## **Re: Hertford Theatre, Hertford – Planning Condition 4**

Temple was contacted by GPF Lewis during November 2023 with regards to reviewing information to support the discharge of Condition 4 for the planning application submitted for Hertford Theatre, Hertford (reference: 3/20/2285/FUL).

This is a letter from Temple for GPF Lewis which documents the specification for a selection of boxes targeting bats, birds and bees for the development at Hertford theatre.

# NESTING BOXES LOCATION PLAN

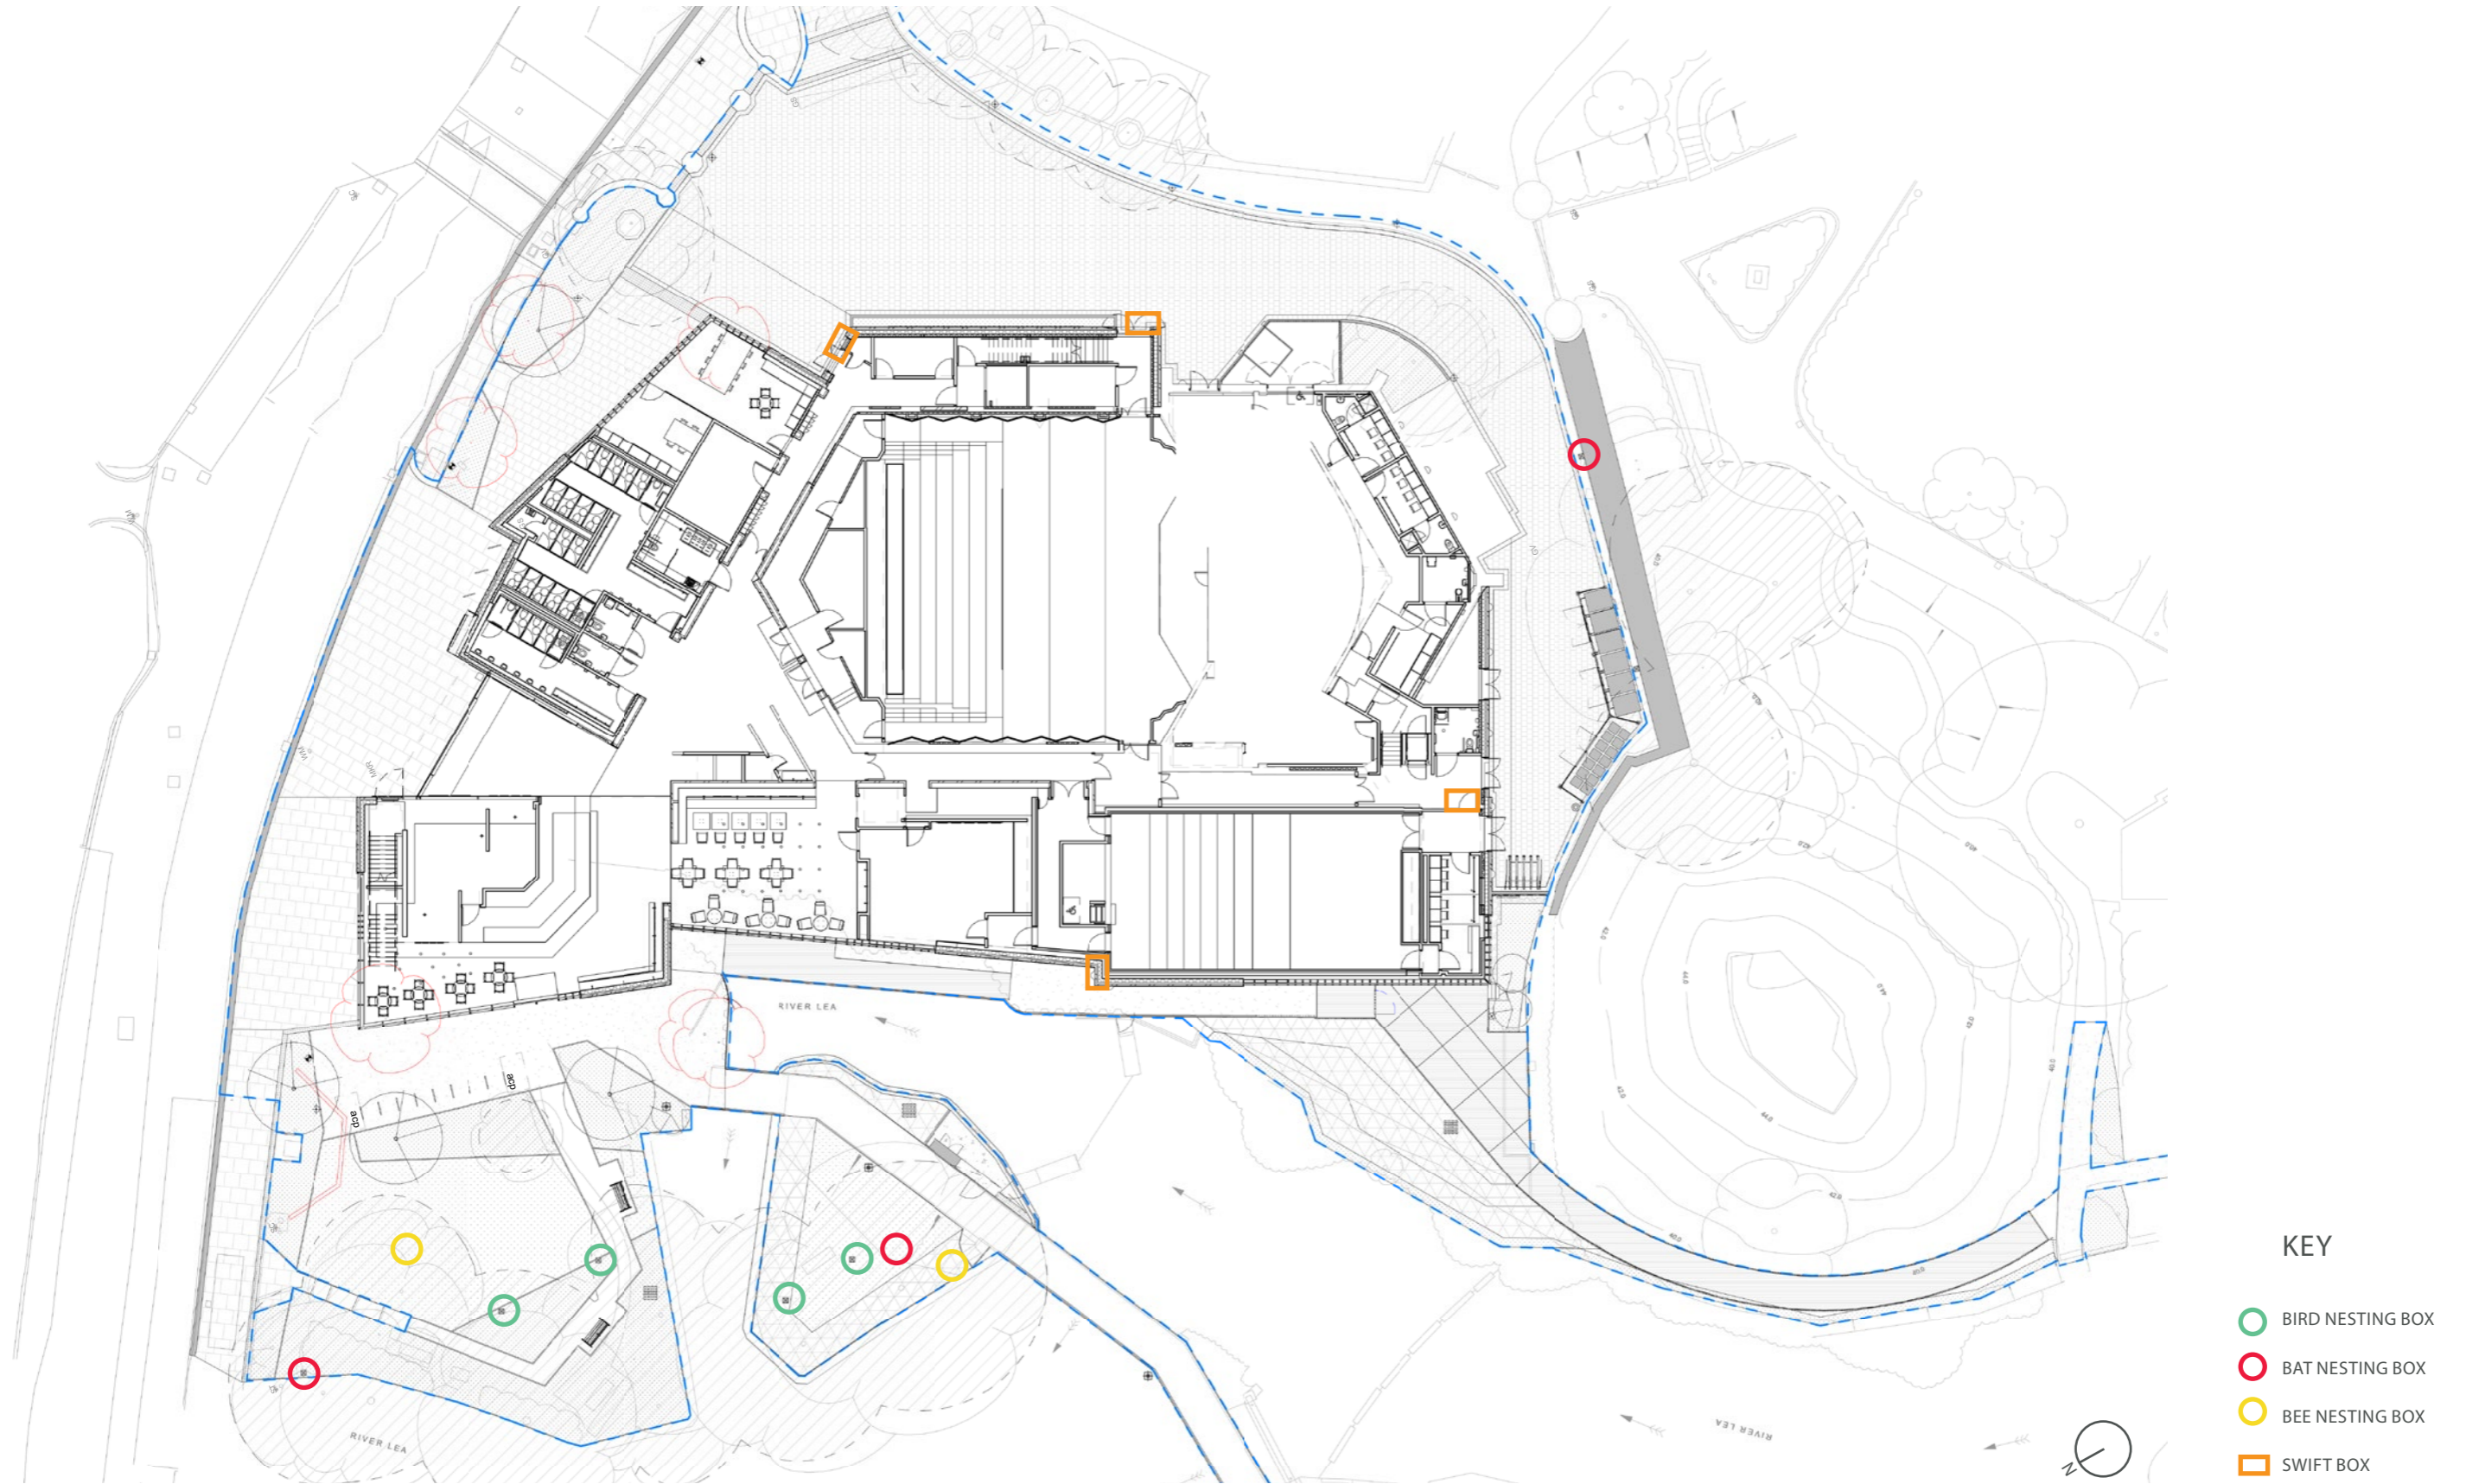
Originally, one bat box was proposed to be installed on a tree in the west and two on the wall in the south of the site. Upon review of the bat box locations and the lighting study (Pritchard Themis, 2023), Temple advised that one of the bat boxes be moved from the wall in the south, to a tree in the west subject to lower lux levels and in a location with connectivity to the river and proposed meadow lawn which are suitable for foraging and commuting, to increase the likelihood of it being used. This has been amended, as shown in Figure 1, Appendix 1.
